From: [Neil McBride](#)
To: [Cottam Solar Project](#)
Subject: Cottam Solar ExAs Questions
Date: 22 November 2023 13:28:57
Attachments: [image003.jpg](#)
[image001.png](#)
[image004.png](#)
[image005.png](#)
[image006.png](#)
[image007.png](#)
[image008.png](#)
[image009.png](#)

Further to the Council's response to the ExAs first round of questions – in respect of Q1.12.26 further details are provided below

9.4: Claimed routes

Sheet by sheet review

Land Plans
 Sheet 9 of 20
 Revision D

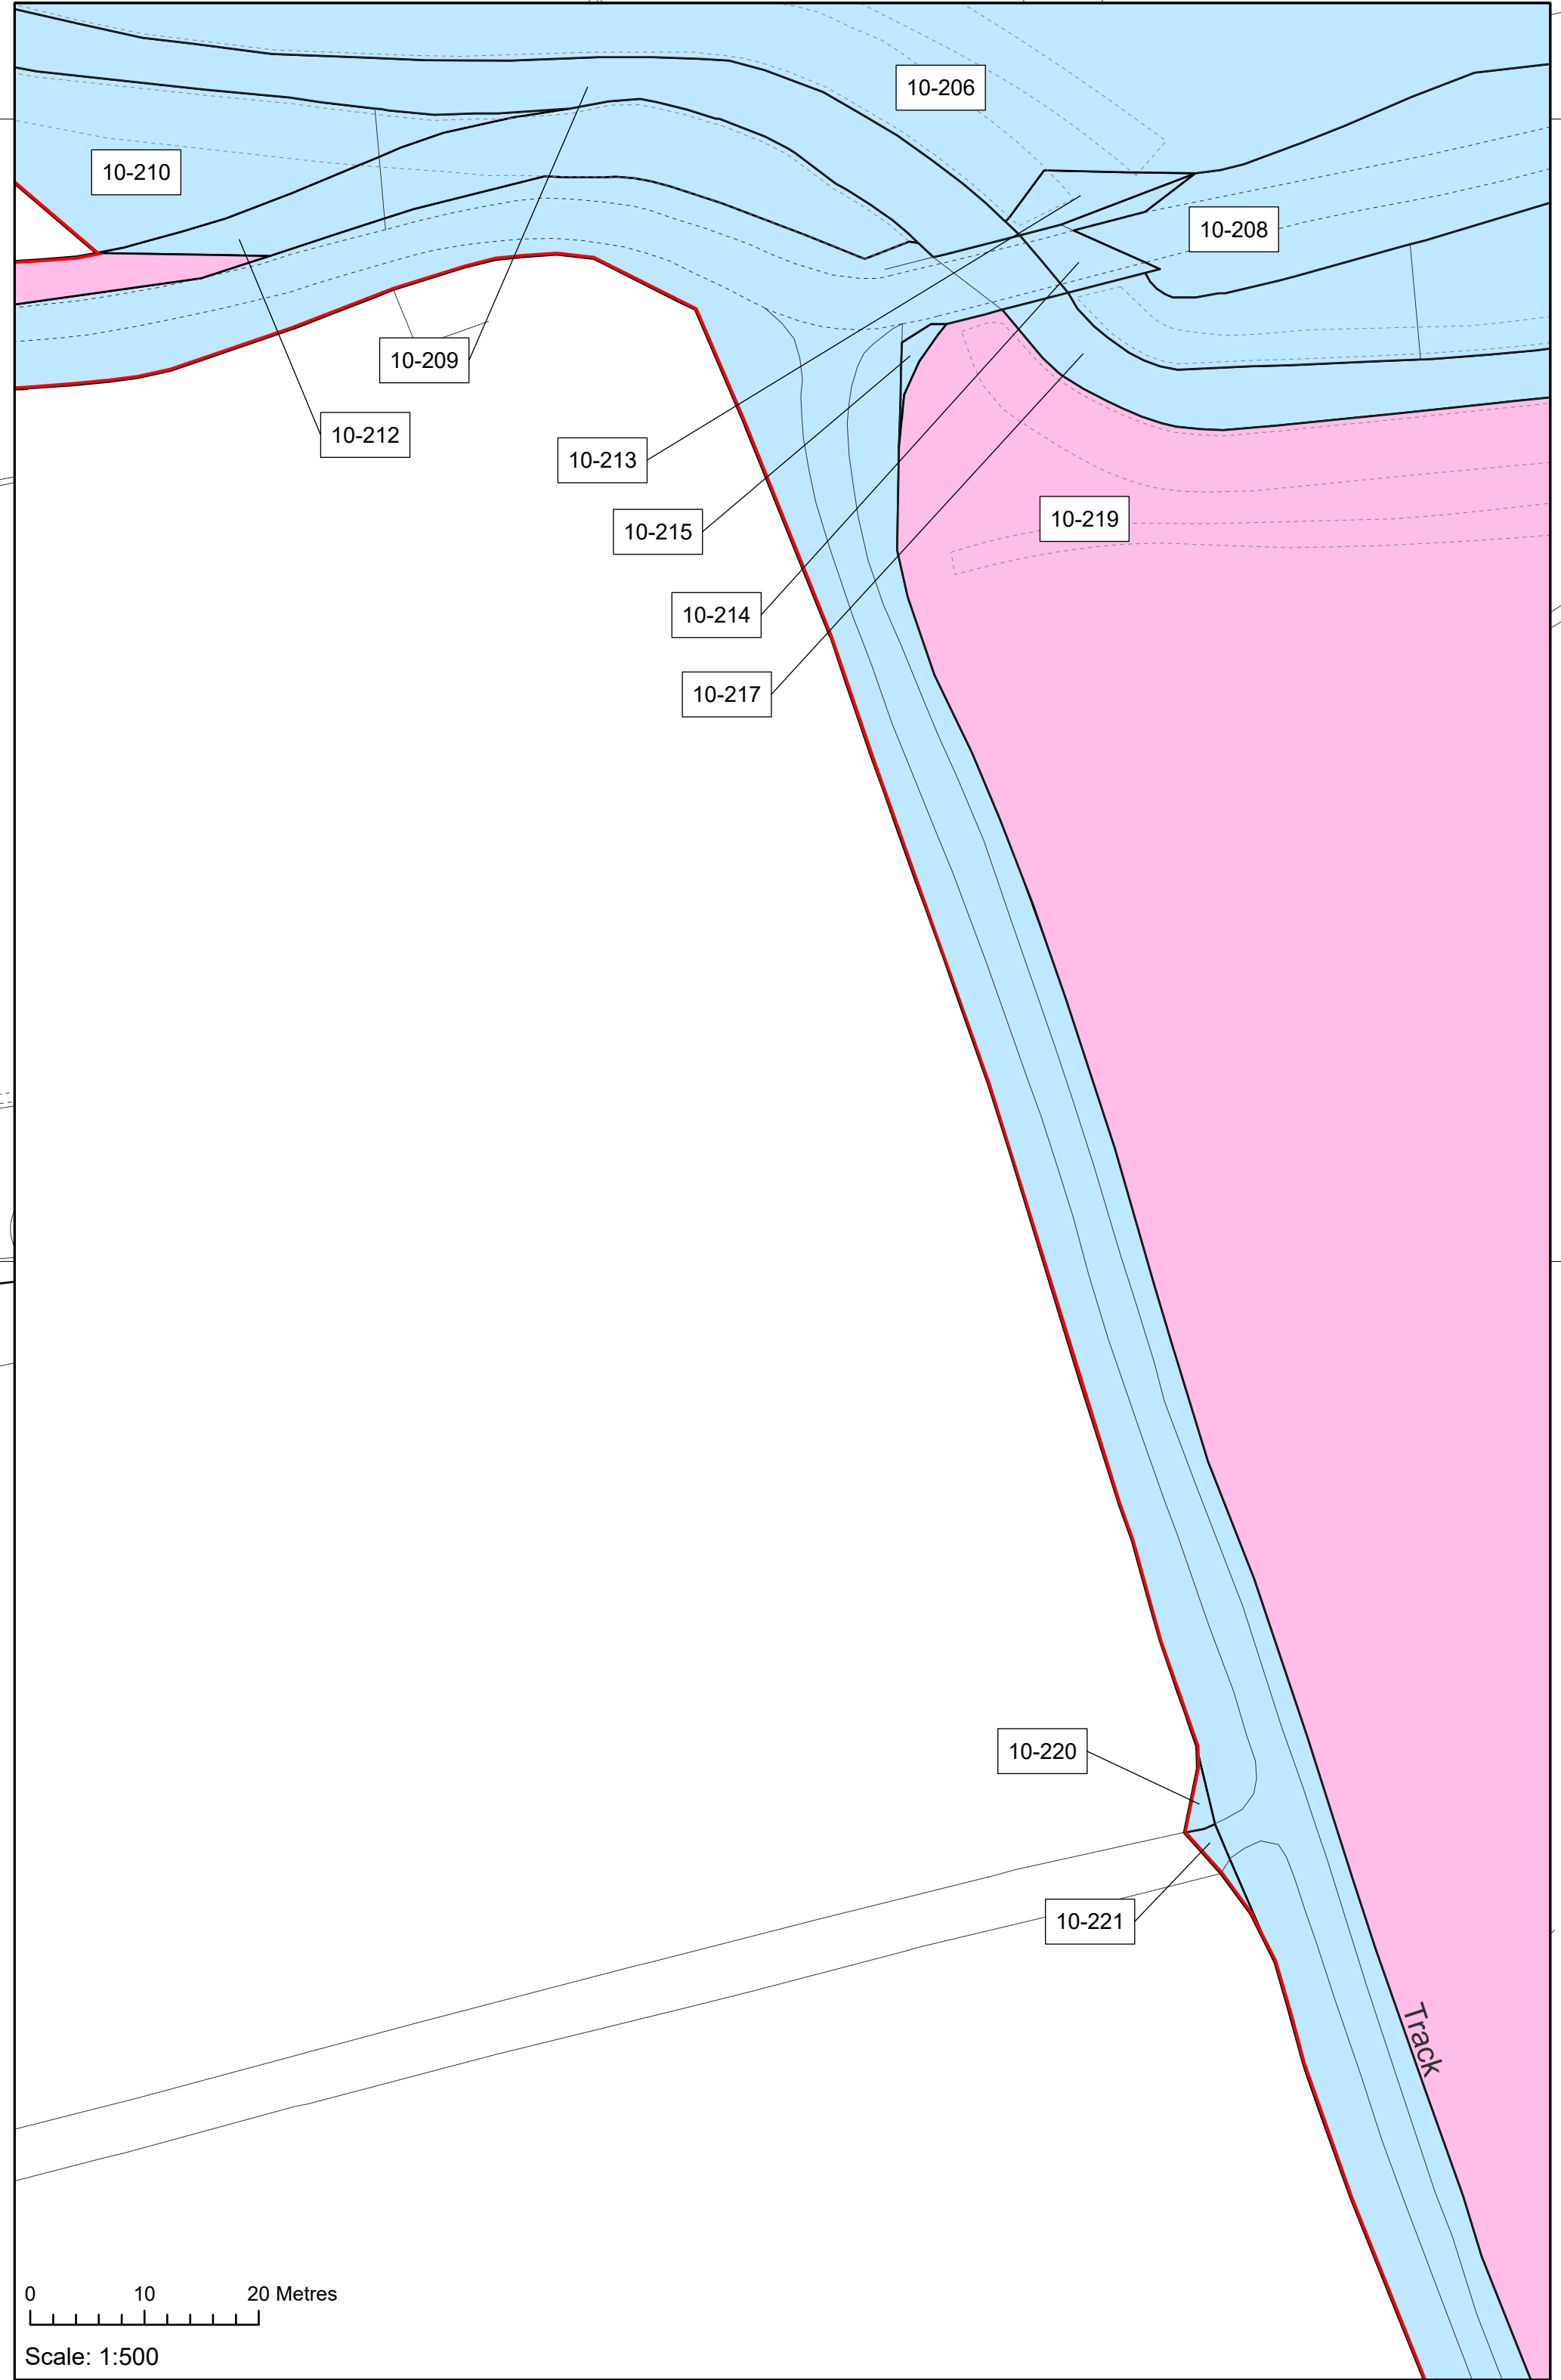
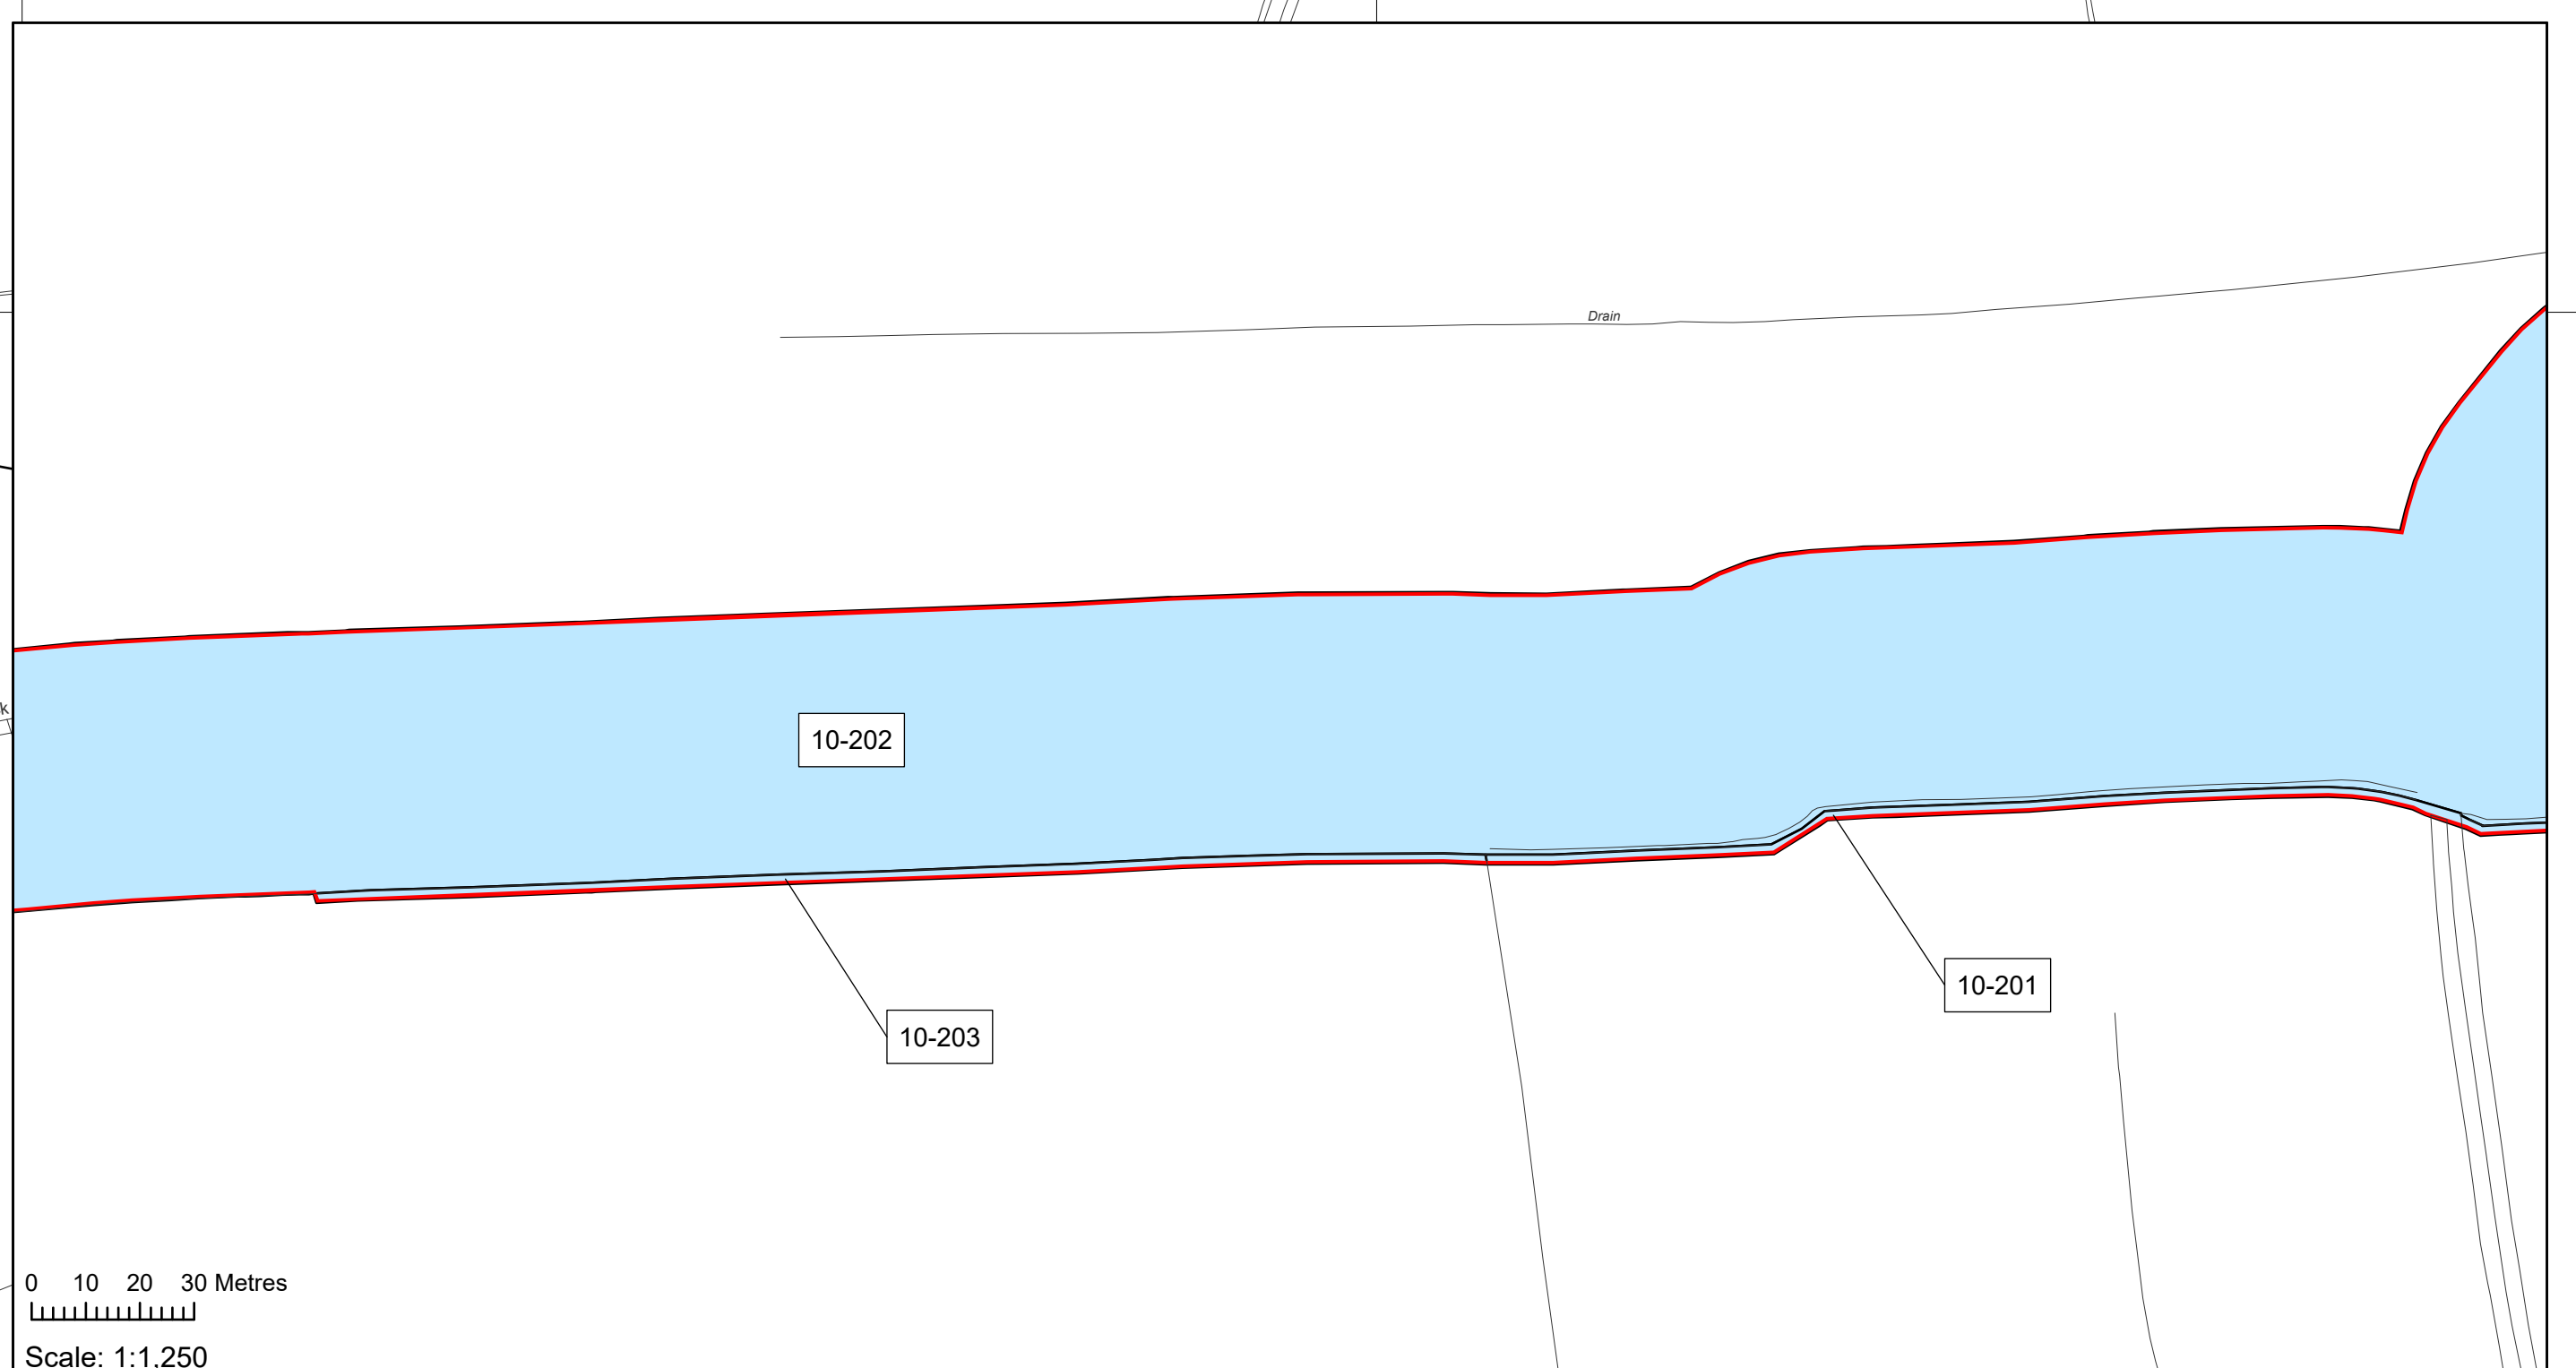
Sheet 9:

Fillingham 86 - Proposed to be temporarily stopped up. More details are needed here and the diversion area included in the plan. More details of how long they are proposing stopping up. As the bridleway is on the edge of the site we are not clear why it would need to be stopped up or diverted.

3.8 of plan sentence is not complete: *"Fill/86/1 will not be crossed by the proposed internal access track. Therefore no management of this PRoW is Y during the construction phase."*

Some issues with this proposal:

- No notice period
- No defined closure period
- No details of reinstatement
